CITY OF PORTLAND BUILDING PERMIT

Job ID: 2011-07-1819-ALTCOMM

has permission to replace front stairs

Located At: 279 BRACKETT

279 Bracket St.

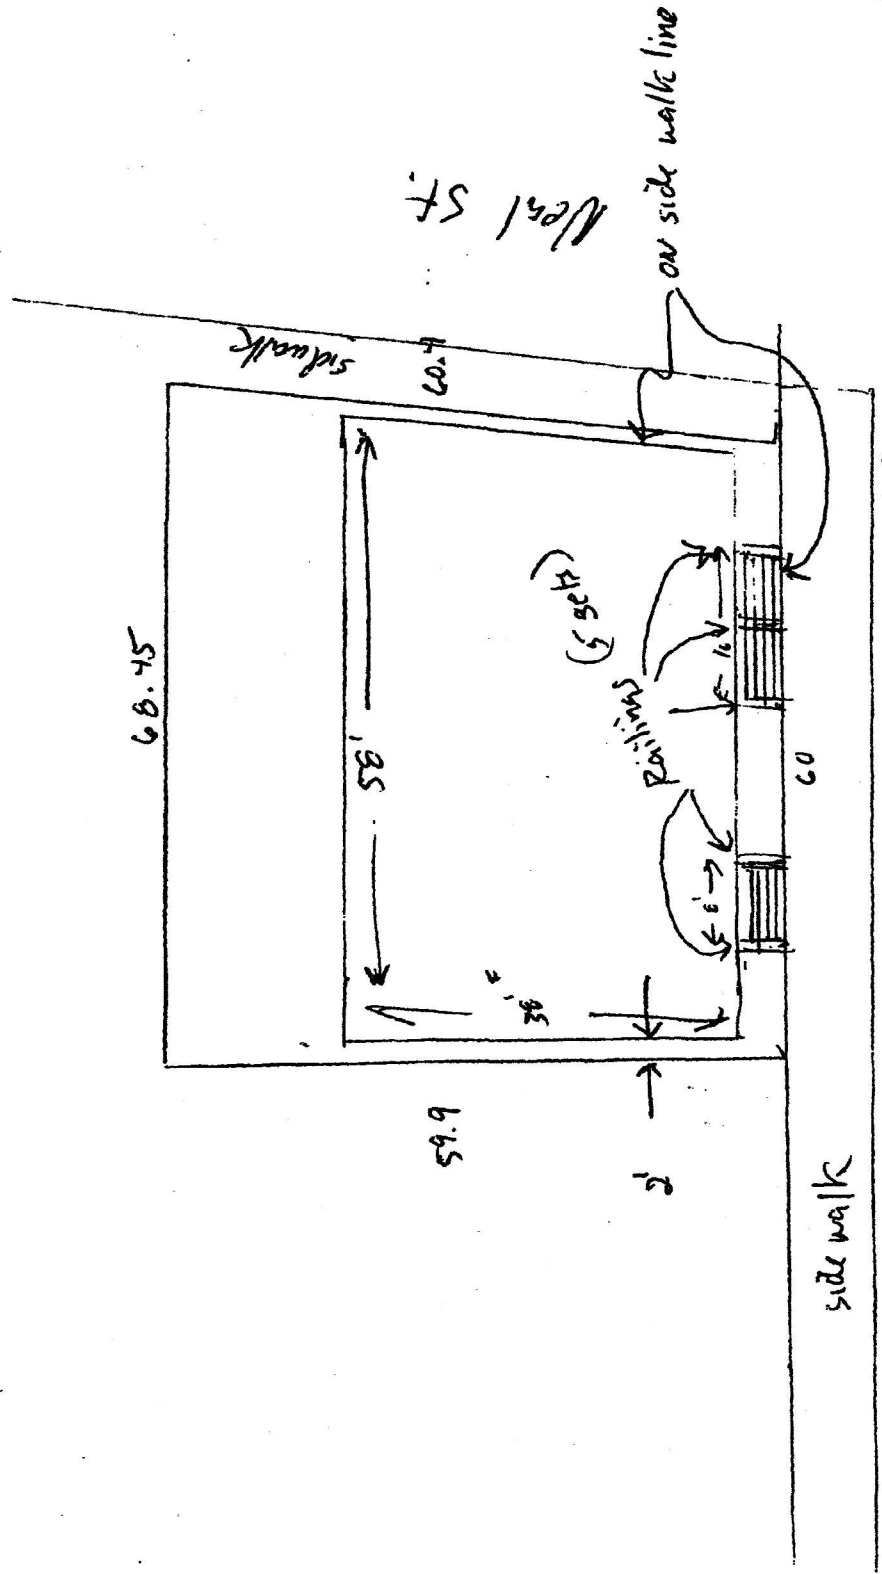
1. This permit is being approved on the basis of plans submitted. Any deviations shall require a separate approval before starting that work. It is understood that the replacement stairs will be within the existing footprint and shall not extend further in to the City sidewalk.
2. ANY exterior work requires a separate review and approval thru Historic Preservation. This property is located within an Historic District.
3. This property shall remain a fourteen (14) residential dwelling unit building. Any change of use shall require a separate permit application for review and approval.

- * Post tops to be pyramidal caps.
- * Railing height not to exceed 34"
- * Handrail to be shaped. (Drawing and notes suggests a flat 2"x4".)

Rise and run shall be no less conforming than the existing stair.

Nosings are not permitted.

Guards and handrails shall comply with Life Safety Code.

The nosing must be ¾".
